# CITY OF ALBUQUERQUE

**Re: 7550 Pan American Fwry**  
**7550 Pan American Fwry**  
**Traffic Circulation Layout**  
Engineer's/Architect's Stamp 4-24-19 (D18D055)

Based upon the information provided in your submittal received 5-22-19, the above referenced plan cannot be approved for Building Permit until the following comments are addressed:

HANDICAP RAMP

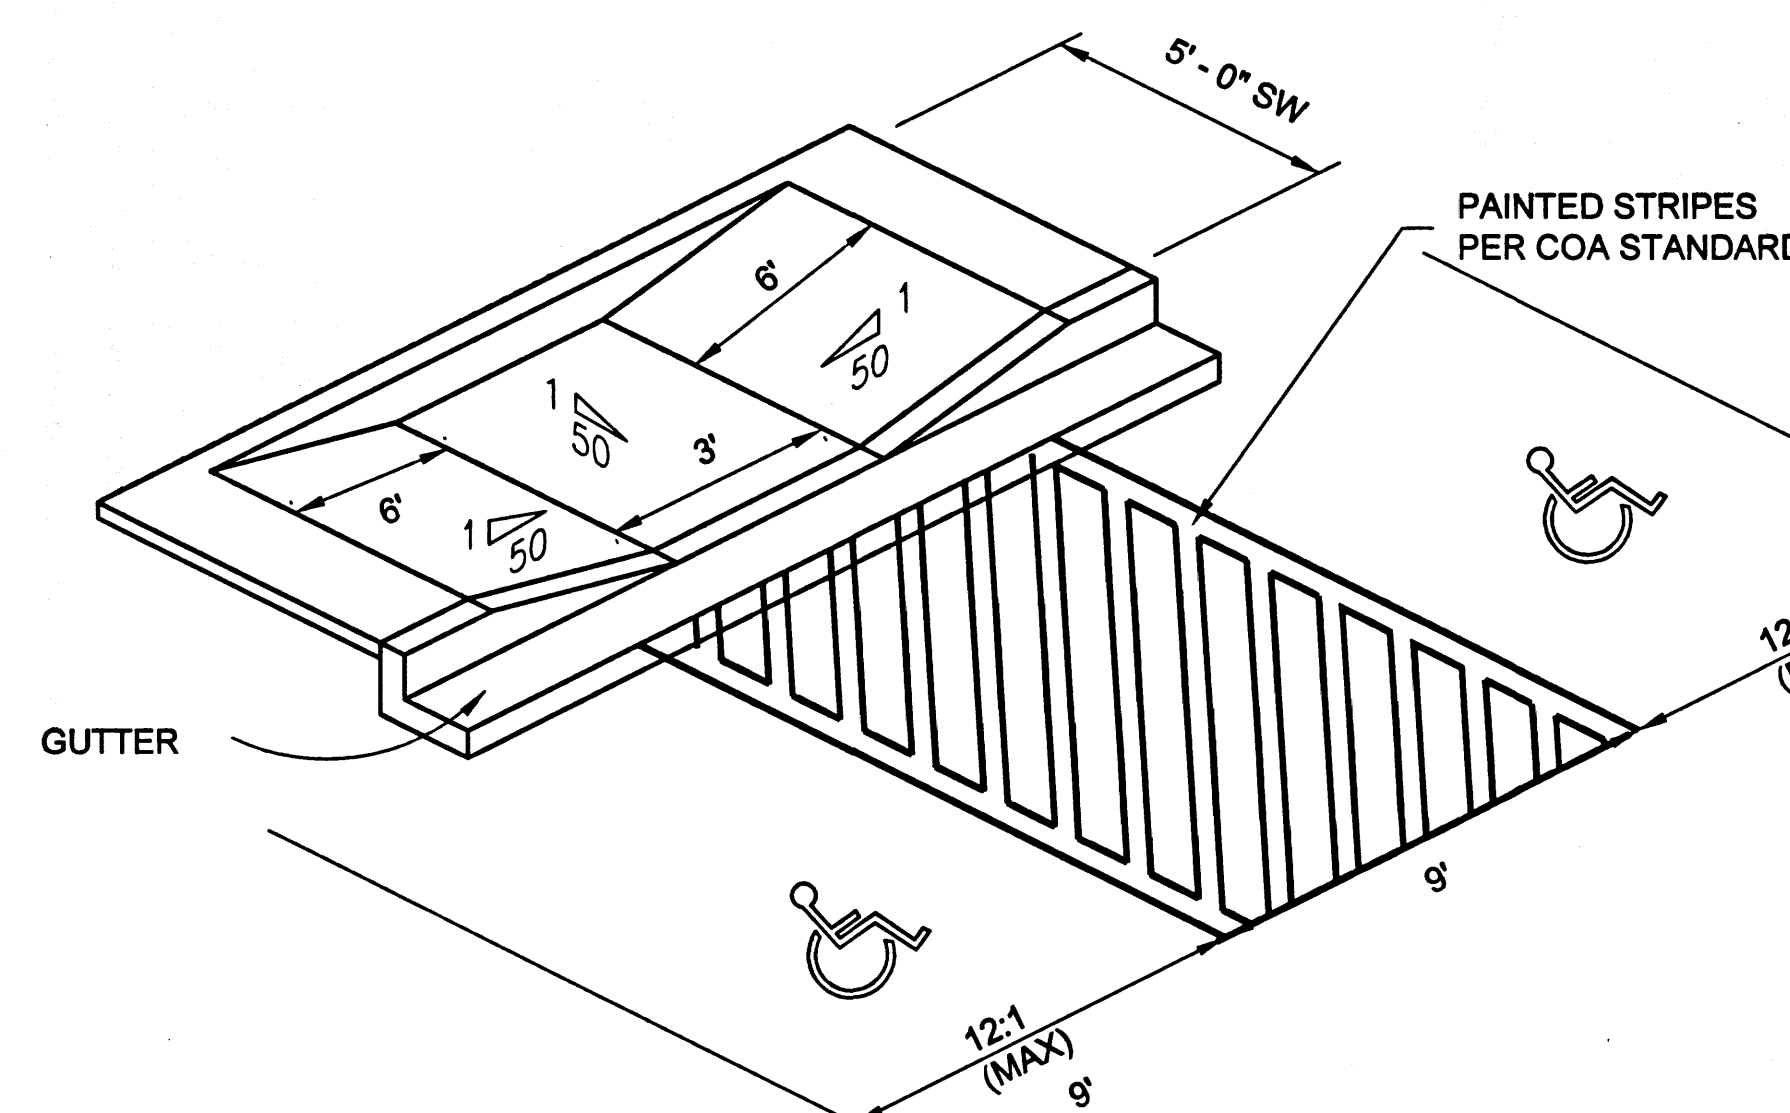
1. Please change 2% to 2.0% for ADA ramp max slope.
2. The ADA access aisles shall have the words **"NO PARKING"** in capital letters, each of which shall be at least one foot high and at least two inches wide, placed at the rear of the parking space so as to be close to where an adjacent vehicle's rear tire would be placed. (66-1-4.1.B NMSA 1978)
3. An approved Plat is required. Please attach a copy when resubmitting.
